ADC PARKS & GREENSPACE ARBORICULTURE

PLANNING APPLICATION: AB/57/15/PL

ADDRESS: Land r/o 74-76 Canada Road Arundel BN18 9HY

BRIEF DESCRIPTION: Erection of 2No 3.Bed semi-detached houses,
associated car parking & erection of a car port

dwg no: PRI17371-03a

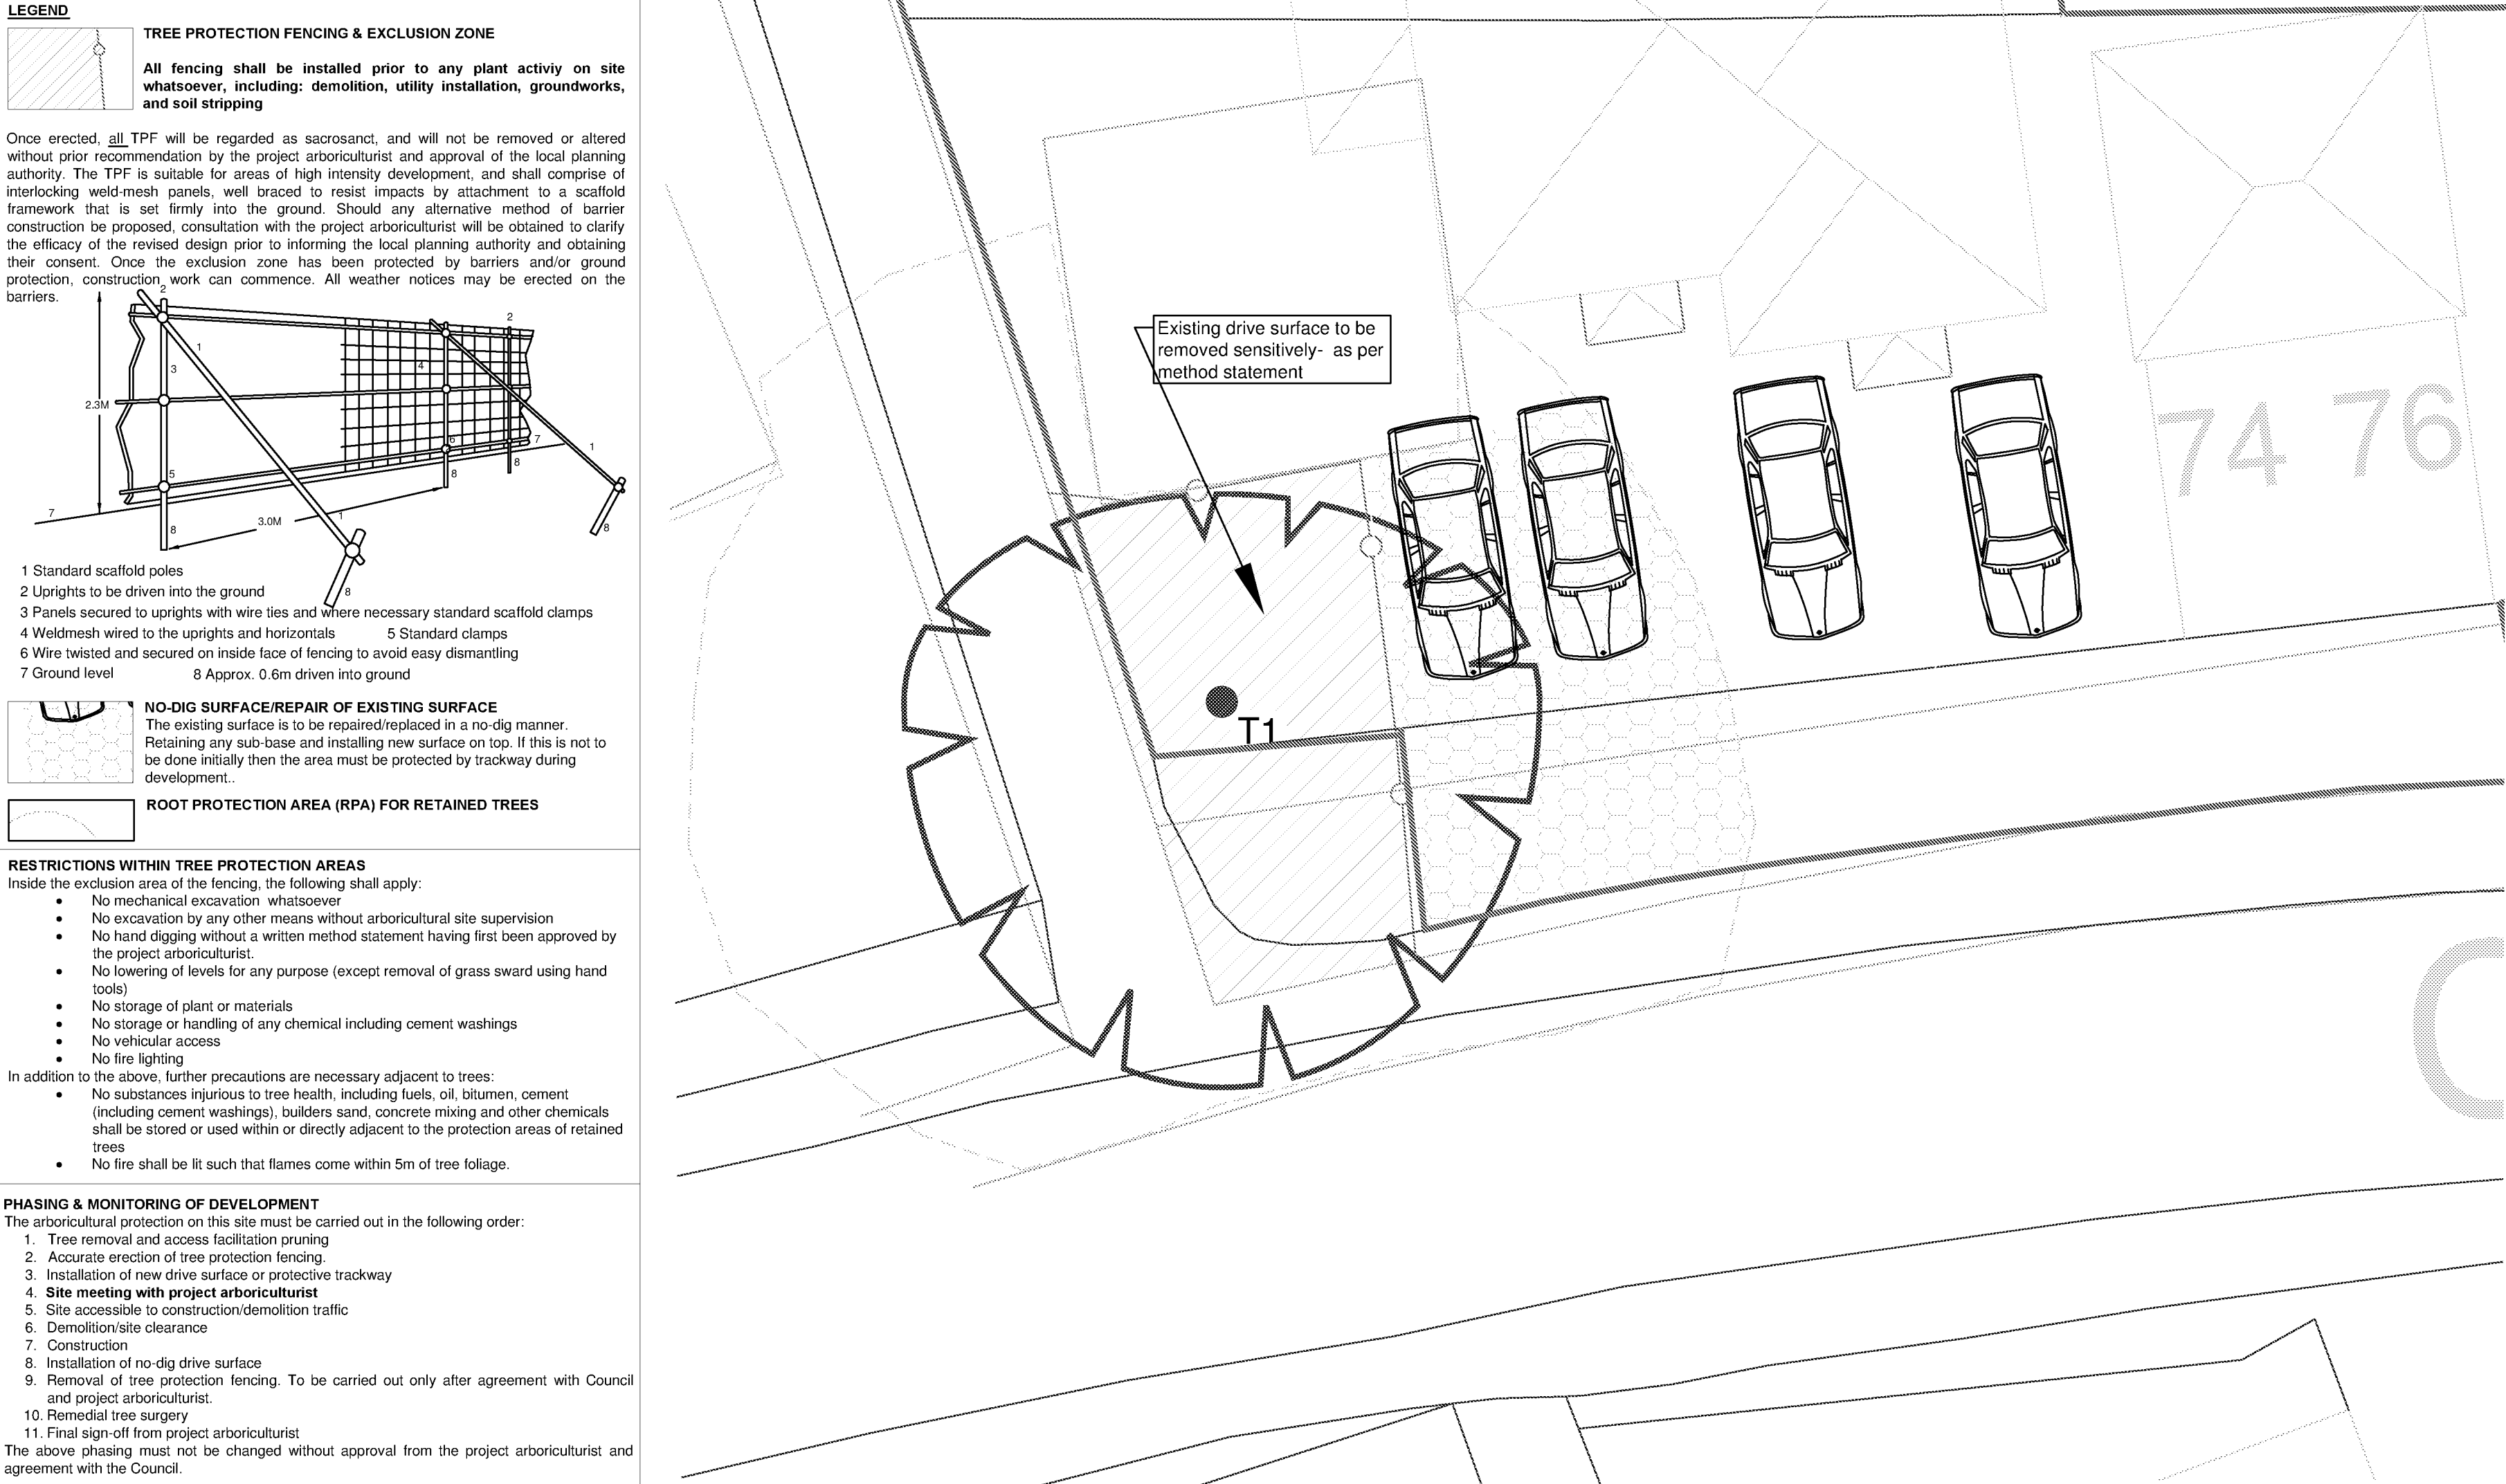
- Currently the cited tree has an existing garage located within the RPA. The applicants statement that this structure is a restraint to root development is accurate, considering the nature of the materials used for the structures assembly (non-porous, solid structure).

- The applicant has also indicated a desire to complete a 5 meter crown lift and remove the epicormic growth present. For the crown lift, only small diameter material would be removed. For the epicormic growth removal, this action is seen as 'good practise', as reduce the chance of tears emerging to limbs and/or the main stem.

- Also the proposed design would move the permanent structures further away from the cited tree, compared to the existing garage. This would mean a more expansive area for further root development of the cited oak tree.

- If any root structure is excavated with a diameter over 25 mm, then the ADC tree officer must be informed, so a site visit can be conducted.
- All methodology for working within the RPA cited in the submitted arboricultural report is adhered to.
- All cited RPA fencing/protecting must be installed as to meet the methodology as stated in the submitted method statement.
- All pruning operations are to meet the standards as set in the BS 3998 2010.
